From: Planning
Sent: 21 May 2021 12:02
To: DC Support
Subject: FW: 21/00588/ADV-2 - Land Including OS7400 5257 4976 2661 And 5257 South Of Salt Way Adj To Bloxham Road Banbury

Planning application:	21/00588/ADV
Location:	Land Including OS7400 5257 4976 2661 And 5257 South Of Salt Way Adj To Bloxham Road Banbury
Description:	2no advertising billboards and house builder flag poles
Type:	Advertisement
Case Officer:	Wayne Campbell

Oxfordshire County Council, as the Local Highways Authority, hereby notify the District Planning Authority that they **object** to the granting of advertisement permission.

SCALE:- 1:1000@A1	DATE:- 11/05/2021	DRAWN:- P.T
STATUS:-	DRAWING No:- 8688 - 112	REVISION:-

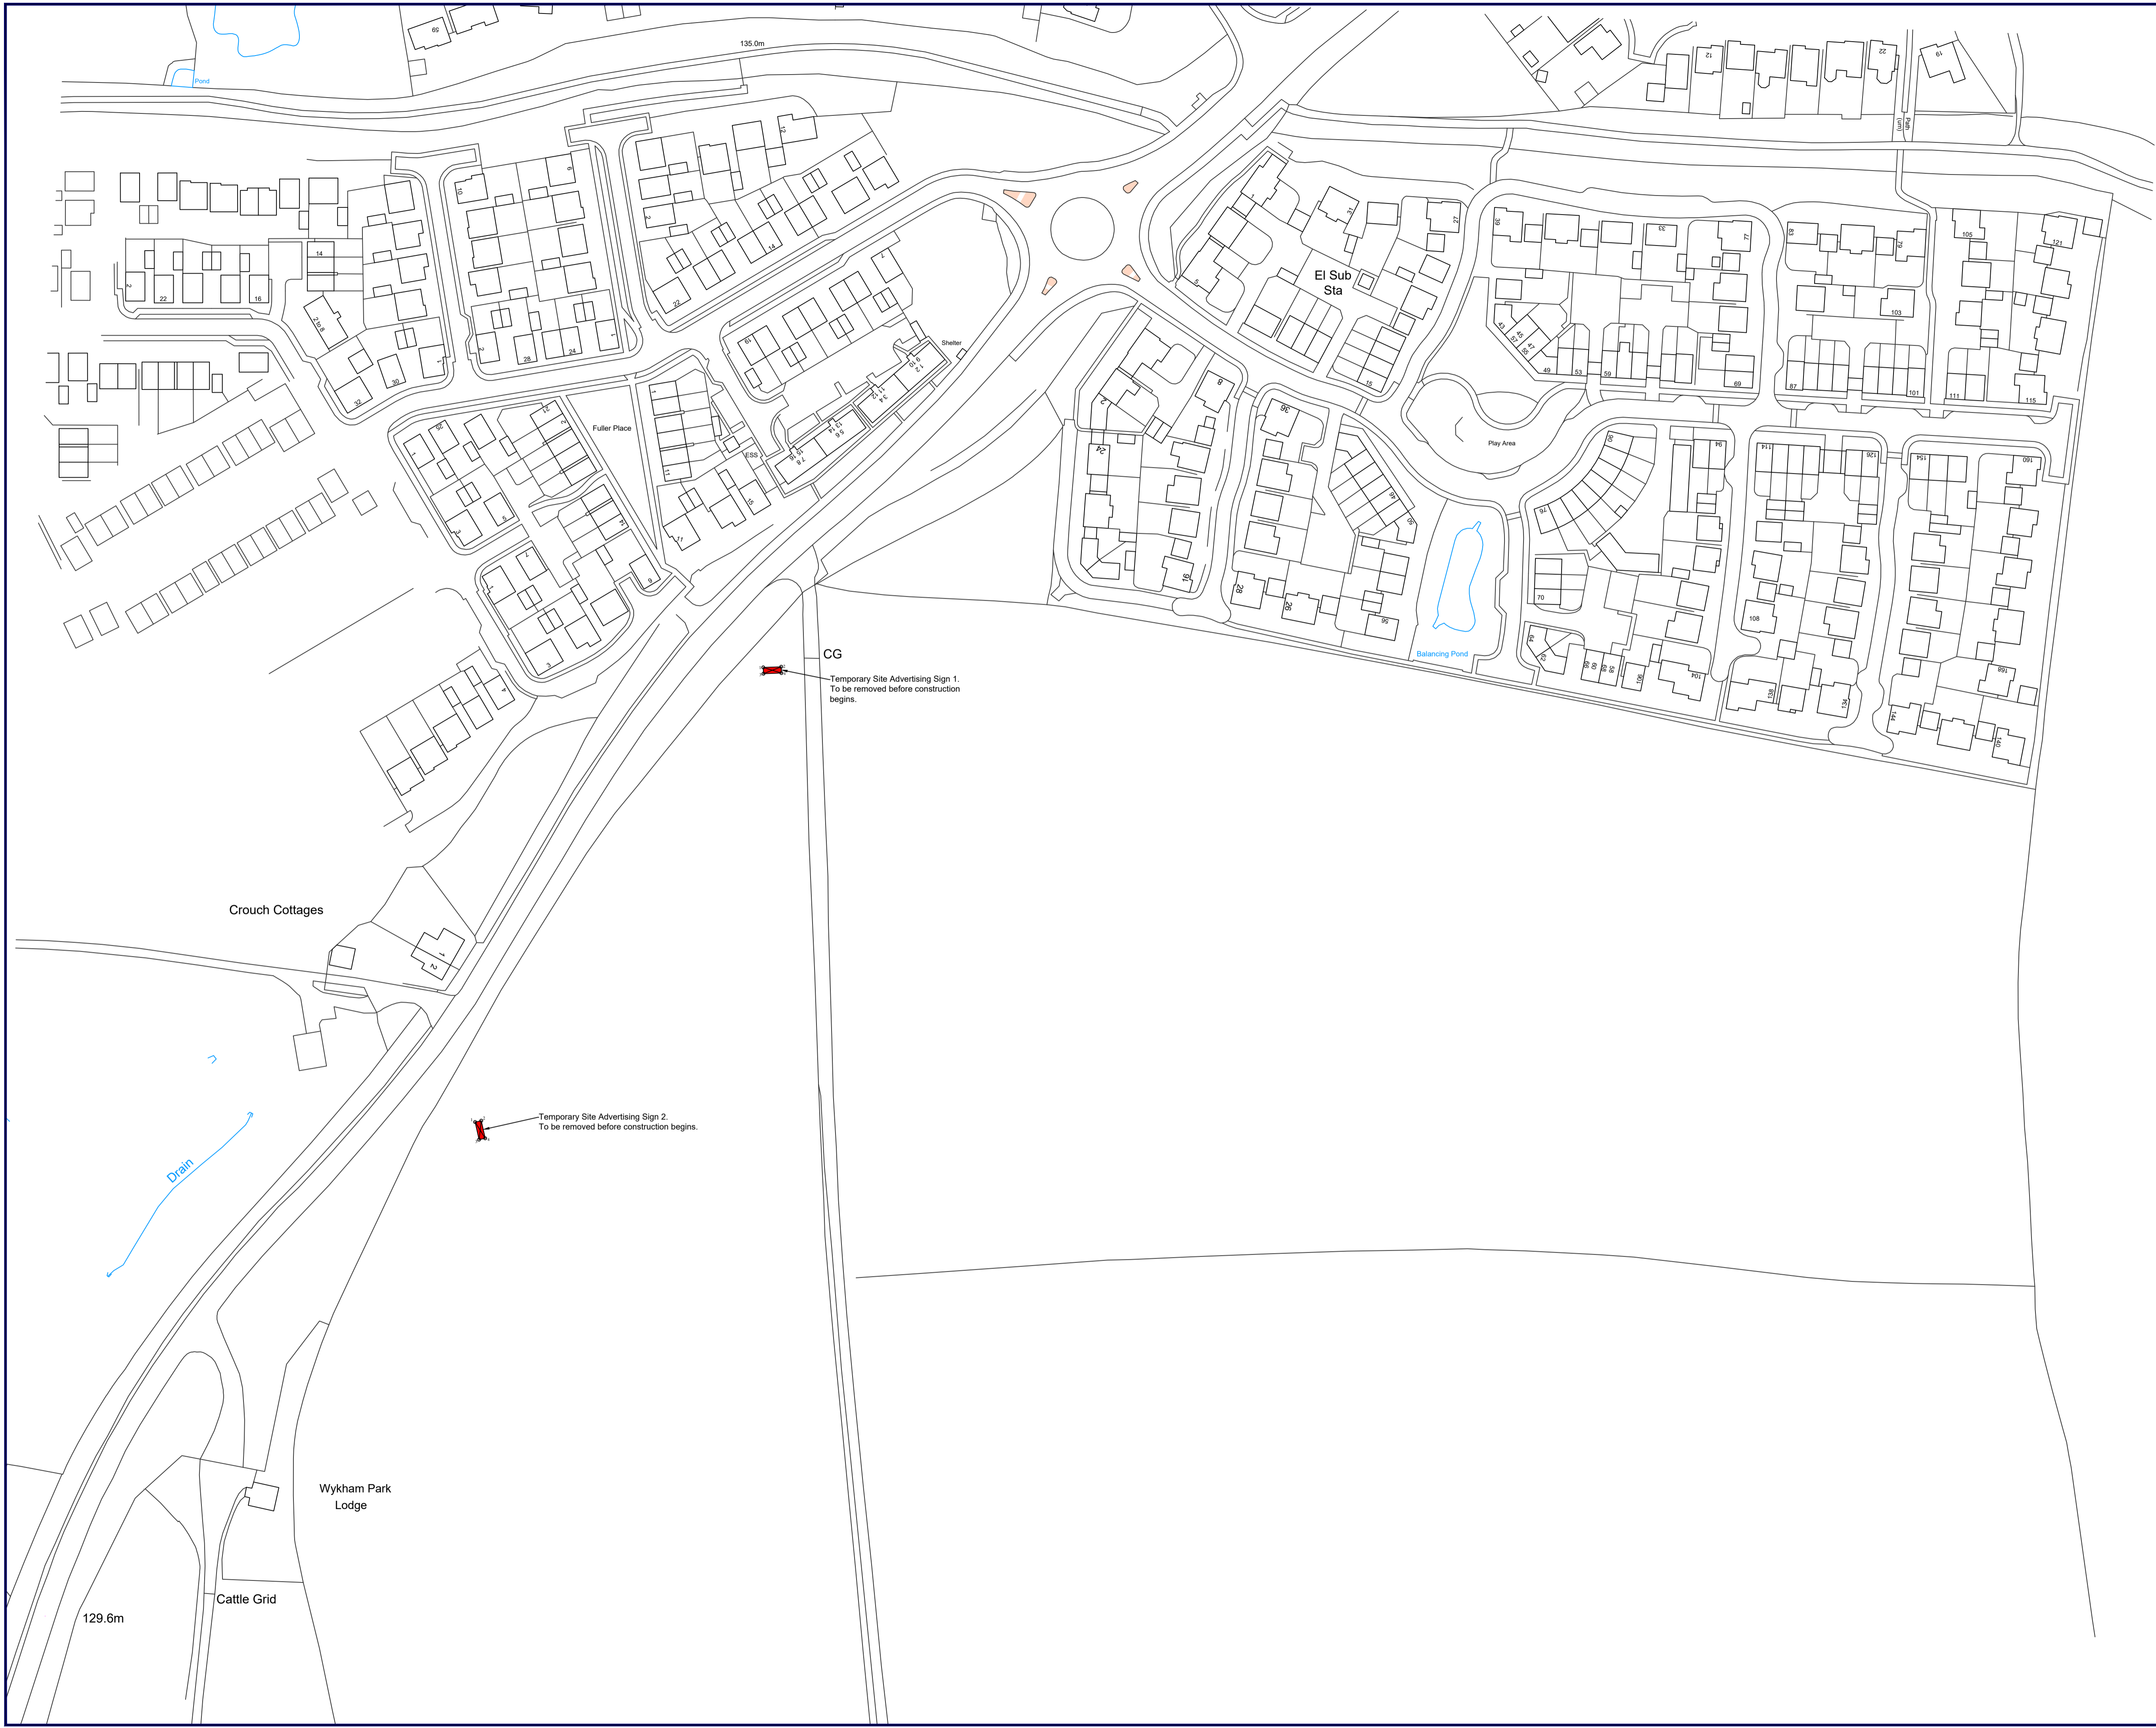
Further to the comments below and the subsequent re-consultation received yesterday, Thursday 20th May, the submitted plan drawing 8686-112 still does not show the proposed highway works, including spine road and new roundabout on the A361. The applicant **MUST** demonstrate to the Highway Authority that the proposed signs will not interfere with these proposed works (including the preparation of proposed construction – verge clearance, hedgerow and tree removal etc), and that these signs will not affect highway safety from either obstructing visibility, or from distracting highway users. It is also assumed that these signs, along with the 14 flag pole signs and two billboards as per the original consultation will remain in situ for a considerable period of time, given the site is allocated for up to 1,345 dwellings as per the [Adopted Cherwell Local Plan 2011-2031 \(Part 1\) | Cherwell District Council](#). It is therefore essential that the applicant provides this information to ensure that the highway remains safe during the entire period of which these signs will be erected for.

The LHA therefore maintains its **OBJECTION** of 23rd April 2021, based upon the applicant failing to demonstrate beyond all reasonable doubt that the proposal will not affect the proposed extensive highway works, and that the proposals will not unduly distract highway users in perpetuity.
